Online Comment

Application H02-0017-26
Location Rear of 92 - 94 North Street Crowland Peterborough PE6 0EF
Proposal Erection of 2 dwellings with associated parking

Name Imogen Colenutt, Assistant Conservation Officer
Address Council Offices The Hub Mareham Road LN9 6PH

title PLOT 2 ELEVATIONS	scale 1:100 at A3	date JUNE 2025
contract UK EQUITY LTD.	revision A - 20/06/2025 DRAWING FIRST ISSUED

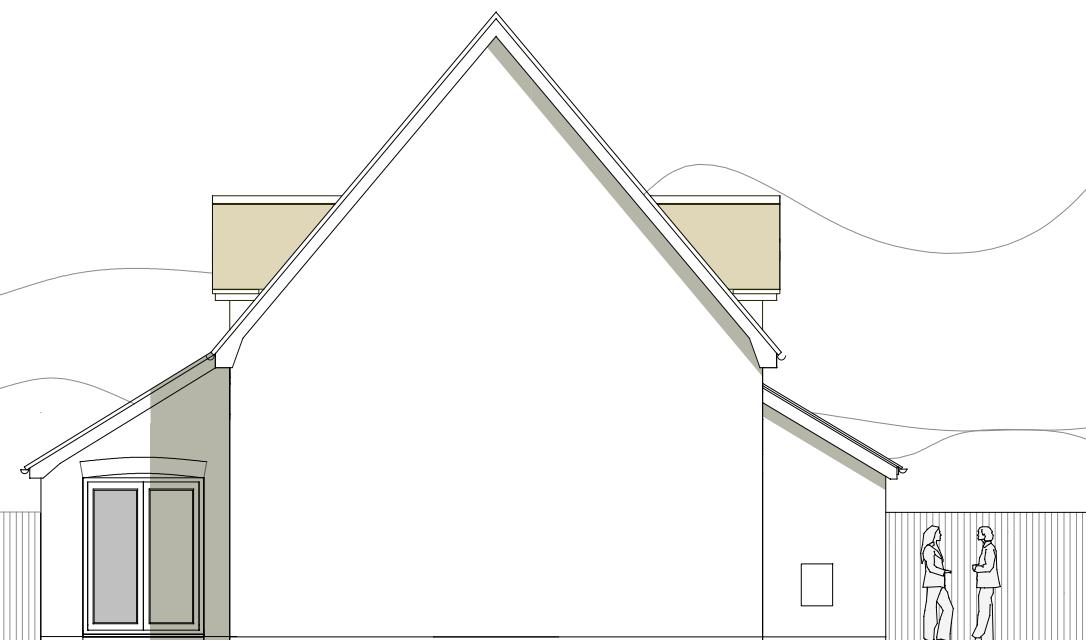
Because the existing plot does not draw attention, the new buildings should remain as subservient and unobtrusive as possible. Plot 2 is particularly visible and would have a reduced impact if it were of a smaller scale.
